From: Iqraa M [redacted]
Sent: 21 July 2020 11:05
To: Sian Eggington
Subject: FW: Request for further information BR/160/20/HH
Attachments: We sent you safe versions of your files; 212 London Rd-Planning.pdf; image001.png

PROPOSED GROUND FLOOR PLAN

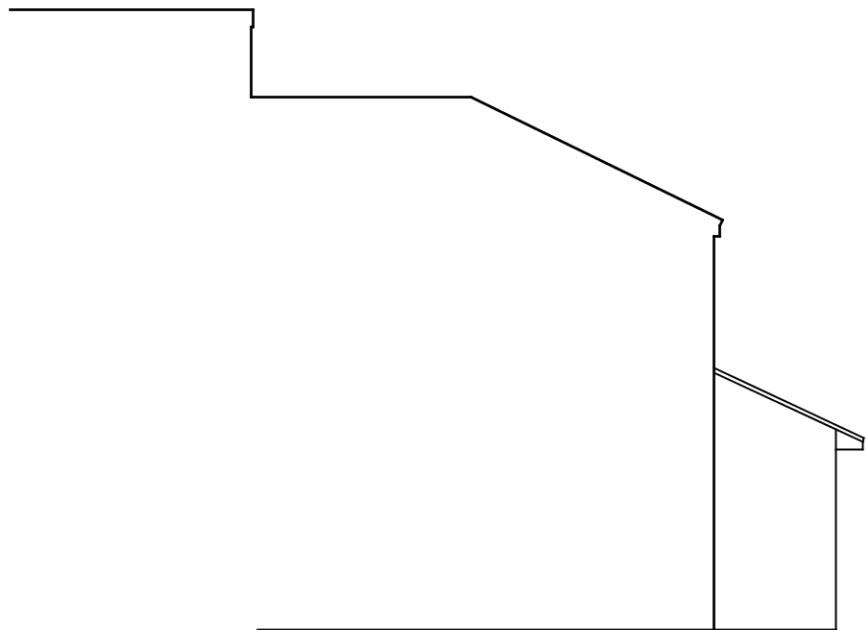
The building line I've outlined in red below doesn't seem to correspond with your proposed ground floor plan. I hope this clears up any confusion.

Unfortunately, the building line in your proposed ground floor is inconsistent with the proposed north elevation. Please amend.

Please find attached plan with dimensions added.

Please find attached amended plan. The scale is actually 1/100.
I agree to the amended description.
